RE: File No. SUB17-004 - Lot Line Consolidation

This letter addresses the changes made to the above Lot Line Consolidation application based on comments received from your office in a letter of incompleteness dated April 10, 2017.

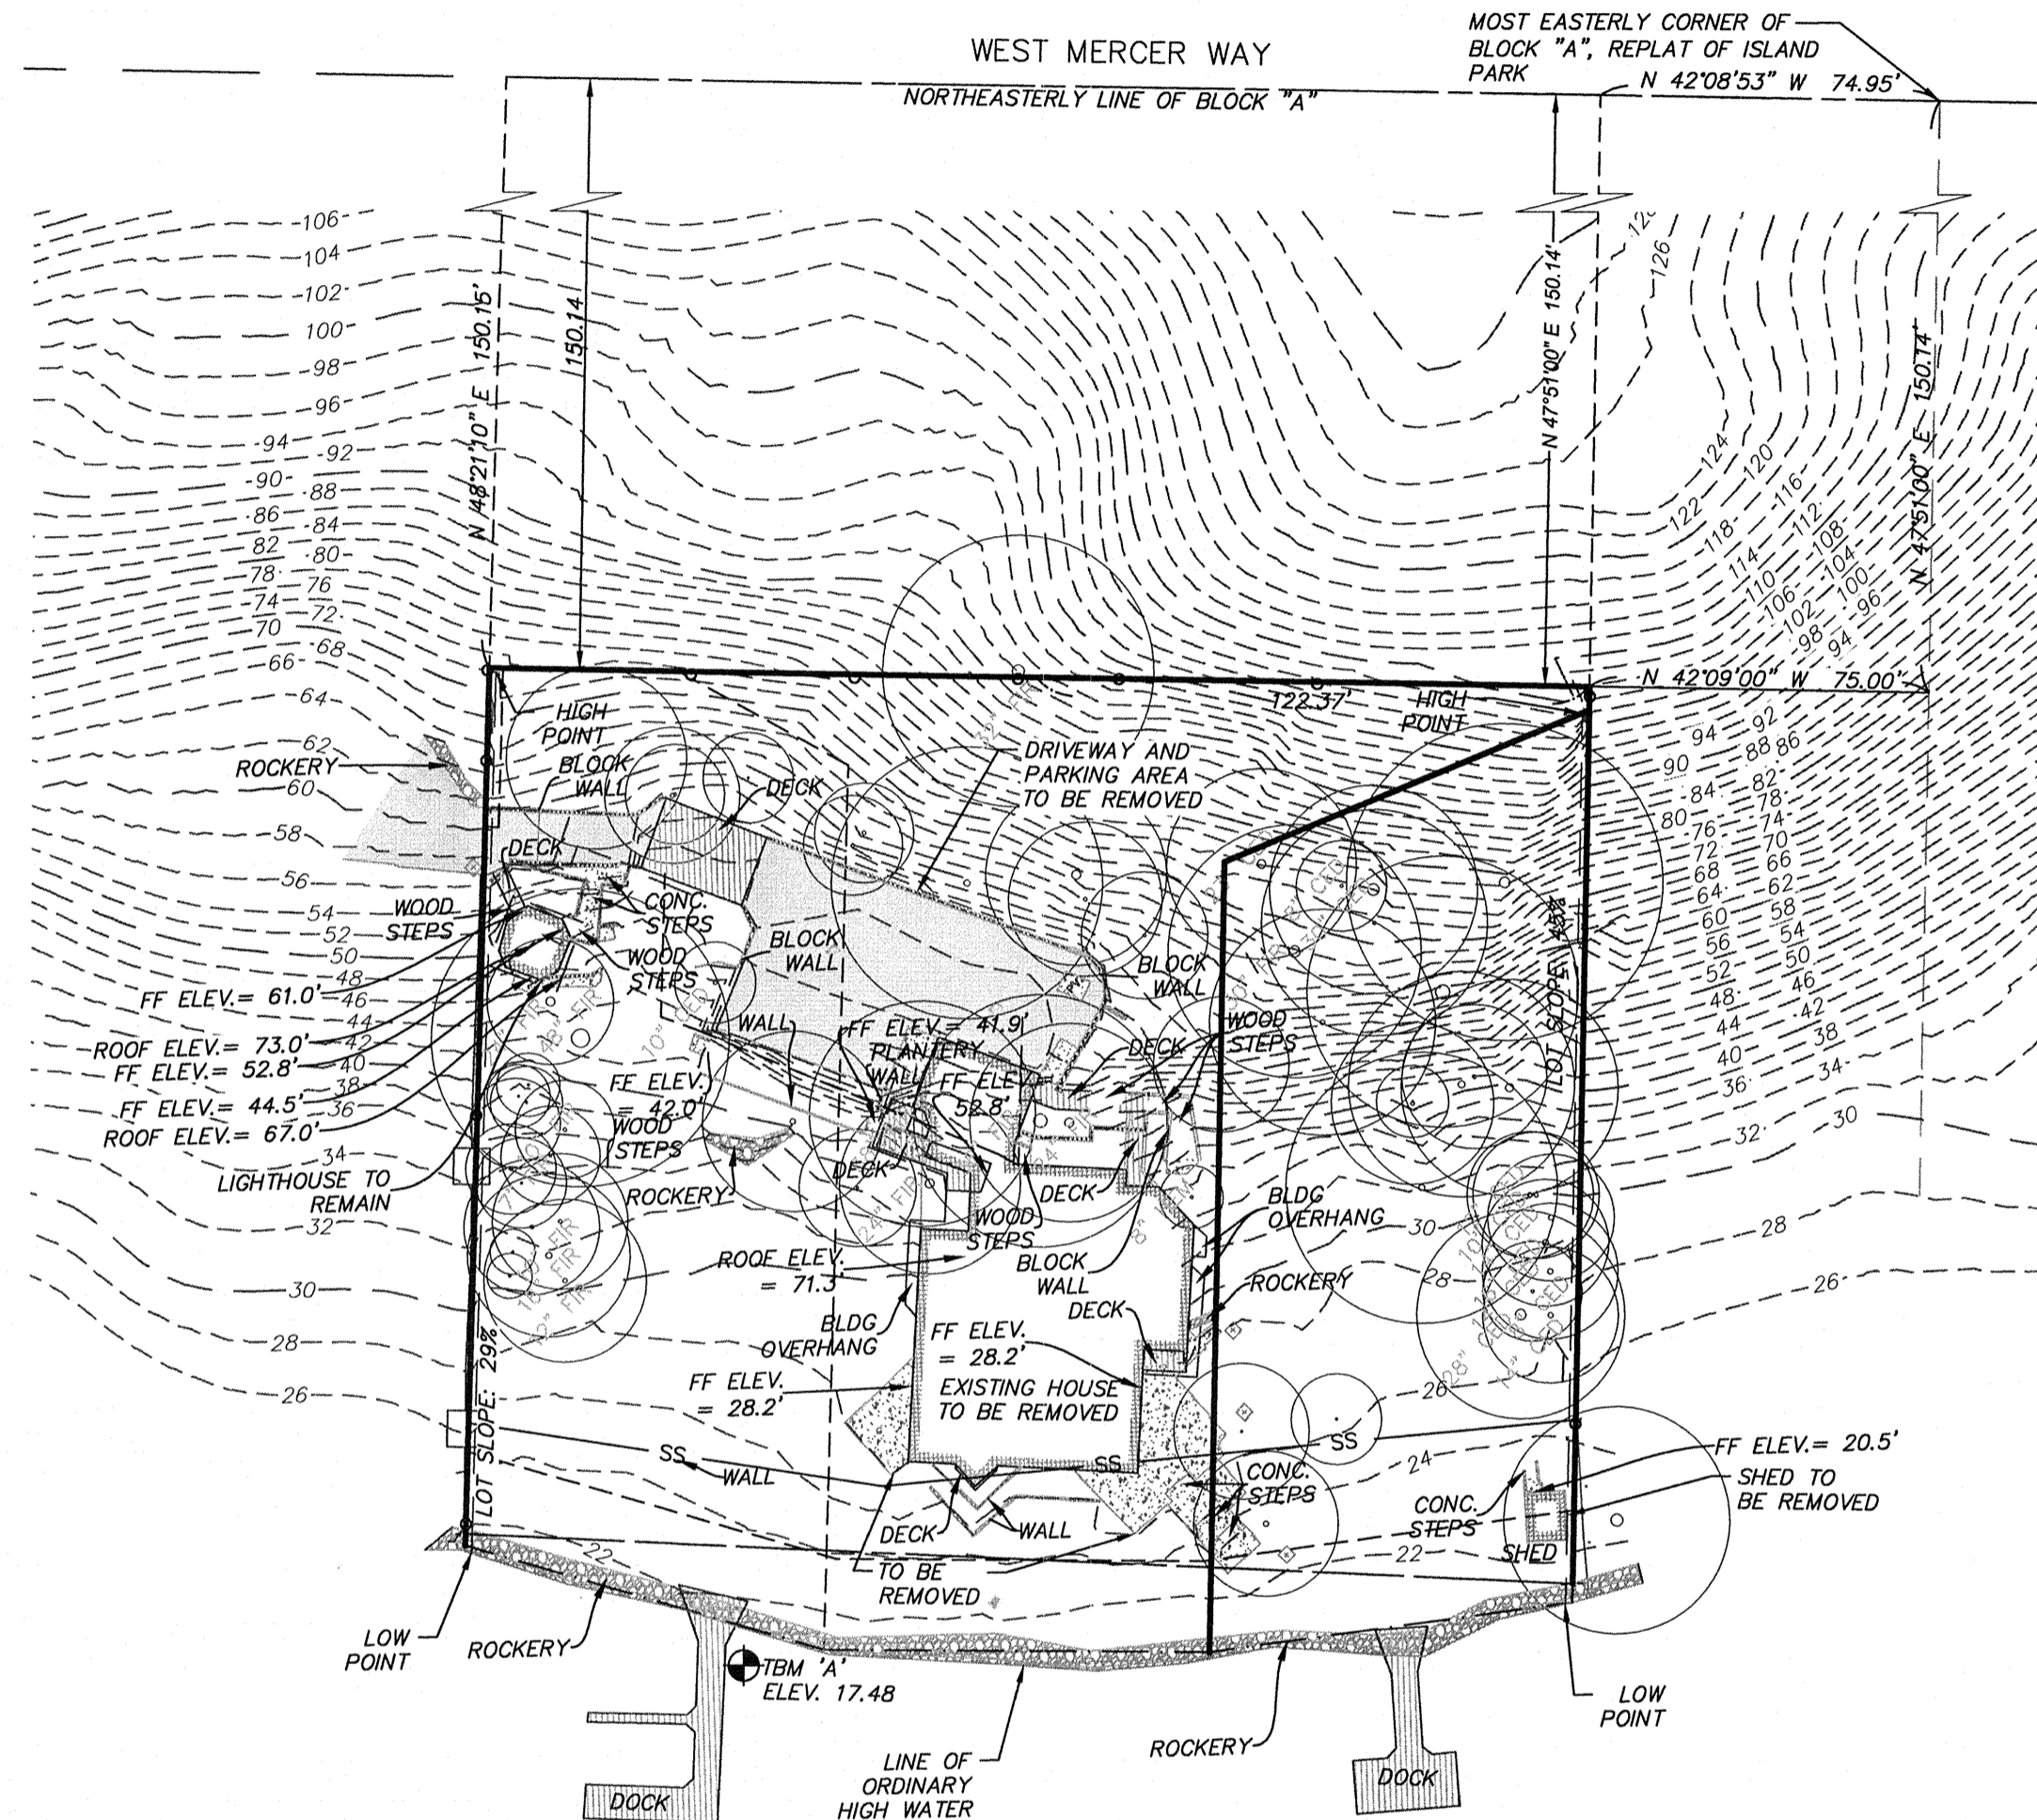
- 6) Please label on the plat the Mercer Island Sewer District easement 5110633, private road easement 3927412, and include in the title report the 3' sewer and drainage easement 5589173. ***The easement to the Mercer Island Sewer District, recording number 5220633 has been approximately shown on Sheet 2 of 3 of the Lot Line Revision plan. Said easement document describes a strip of land 20 feet wide as being the strip in which the easement is contained. The 20 foot strip of land is shown on said plan. The exact location of the sewer easement and the sewer line is unknown. The private road easement, recording numbers 3860939 and subsequently 3927412, has been notated on the plan on Sheet 2 of 2, although the easement itself does not lie within the subject boundary. This private road easement was created back in***

1948, before the parcel was subdivided, when there were just two parcels in existence. Recording number 3860939 was the original document creating said private roadway easement. Recording number 3927412 was recorded in 1949, to extend the private roadway easement to include the entire portion of roadway existing at that time. The 3' sewer and drainage easement 5589173 has already been listed in the title report, certificate number 0091236-06, effective date of March 29, 2017 at 8:00am, submitted to the City of Mercer Island, under Schedule B Special Exceptions, Item No. 20.
